File Ref. No: FRN16/1725 BFS19/1827 (8000007686)
TRIM Doc. No: D19/44692
Contact: Senior Firefighter Arthur Brown

27 June 2019

**Exhibition of Environmental Impact Statement (SSD 10154)
Qantas Flight Training Centre
297 King Street Mascot
Lots 2 & 4 DP 234489, Lot 1 DP 202747, Lot B DP 164829 and Lot 133 DP 659434**

LEGEND - SITE ANALYSIS

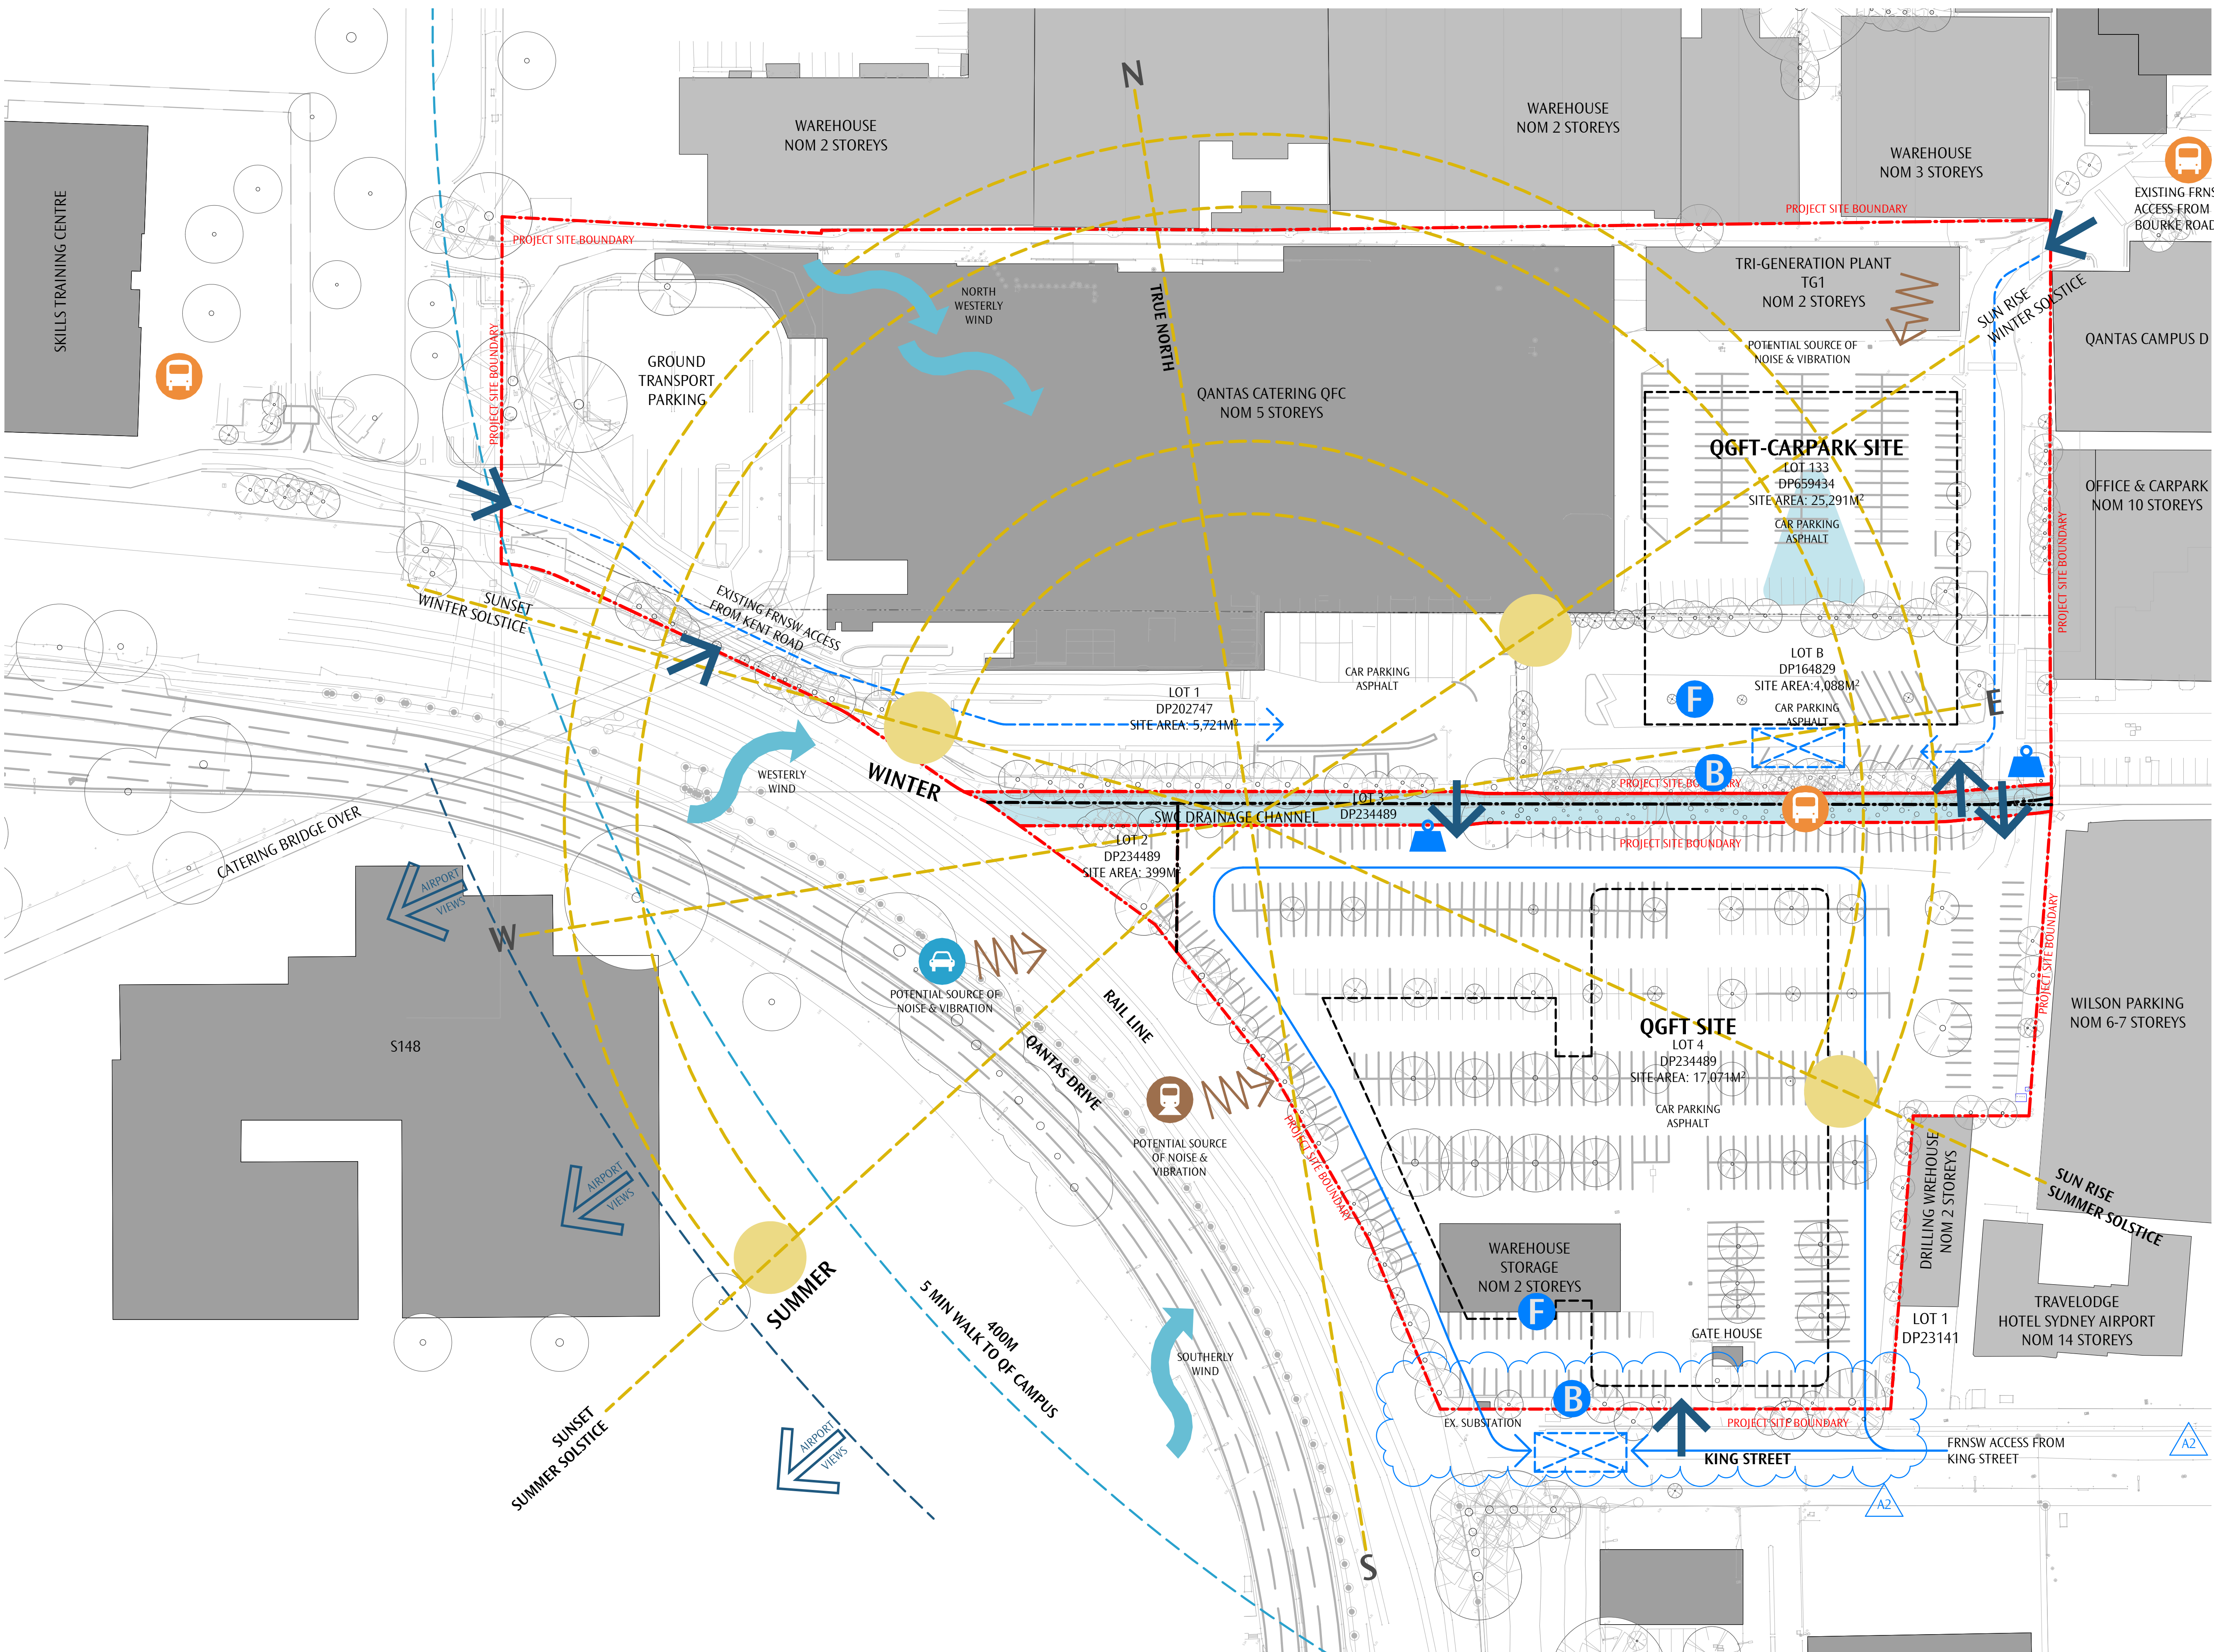
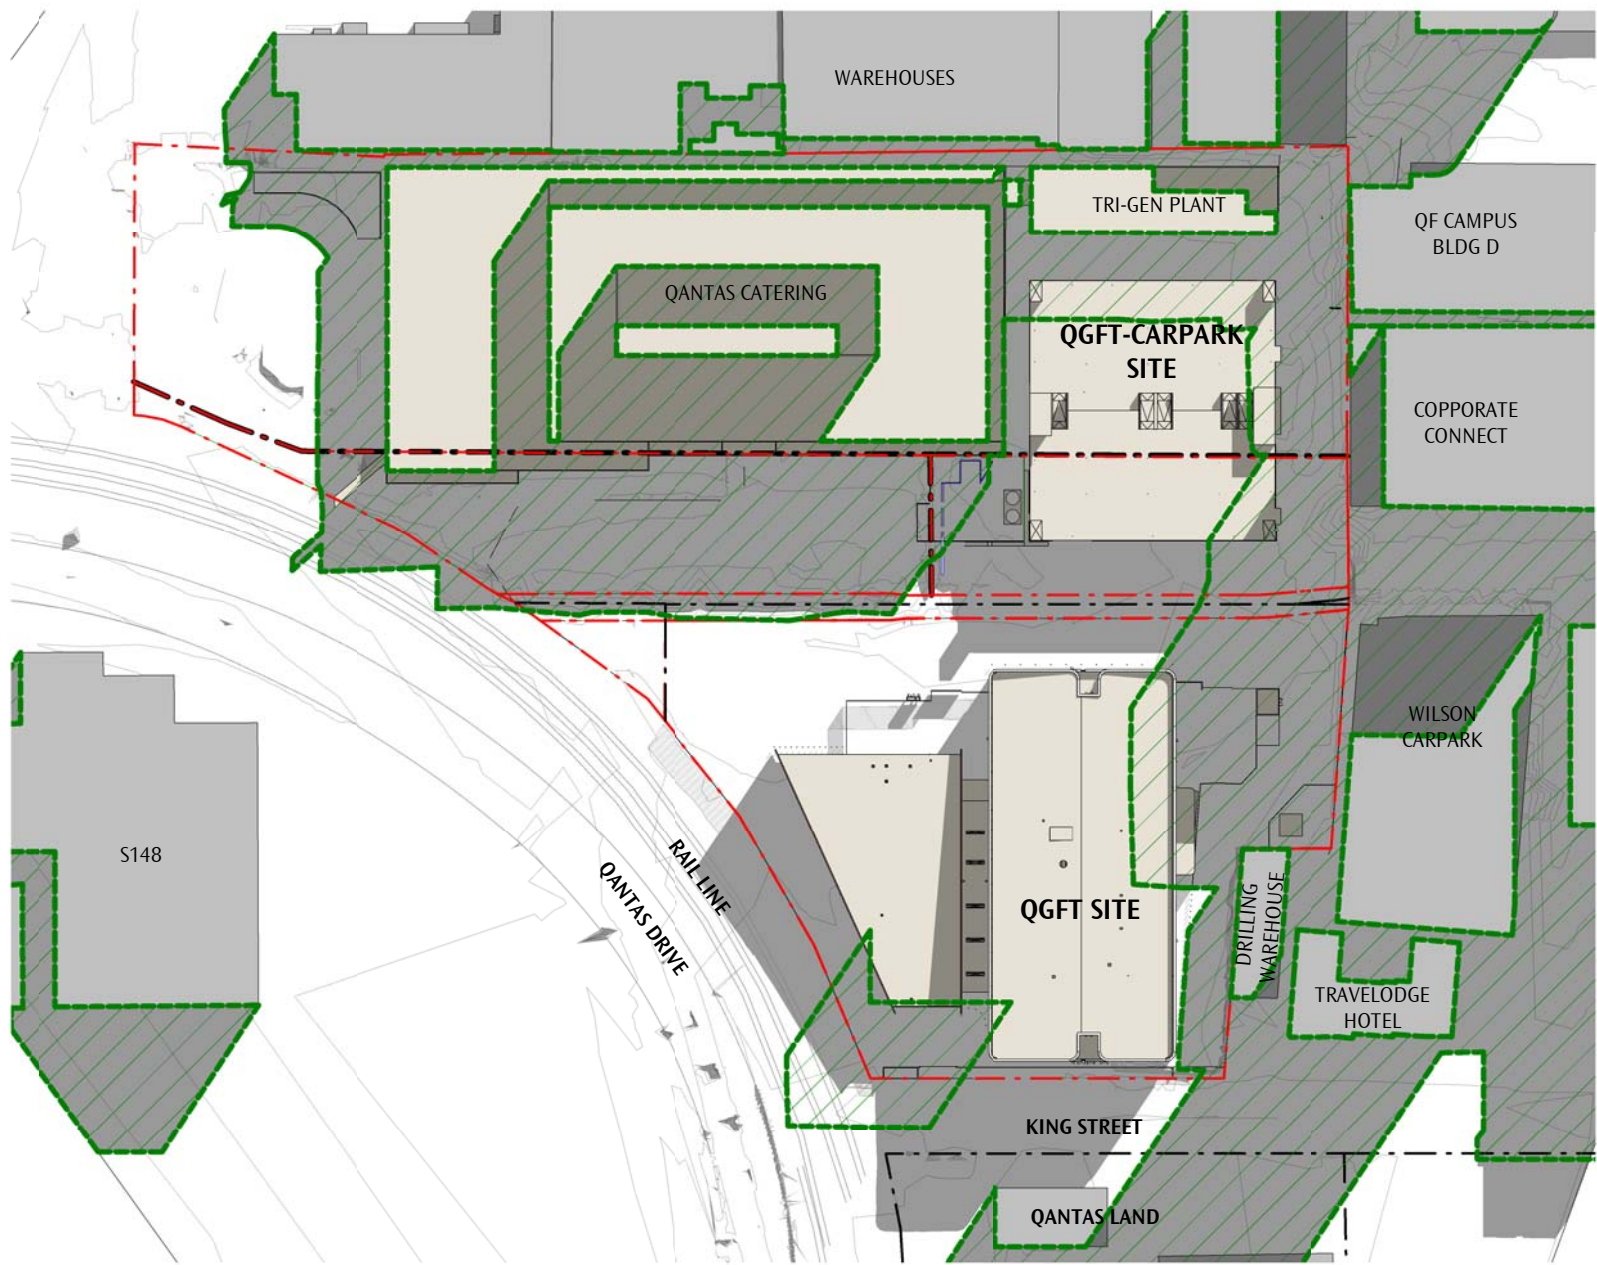
- i) The location of the fire hydrant booster assemblies for both the Flight Training Centre and the Carpark are easily accessible by FRNSW appliances
- ii) The use of manual call points for the activation of an emergency warning system is not an automatic response. The EWIS is to be activated automatically to ensure the safety of the occupants.
- iii) Road widths, turning circles, bends and roundabouts, are provided compliant with FRNSW policy No. 4 – Guidelines for Emergency Vehicle Access (link provided).
http://www.fire.nsw.gov.au/gallery/files/pdf/guidelines/vehicle_access.pdf
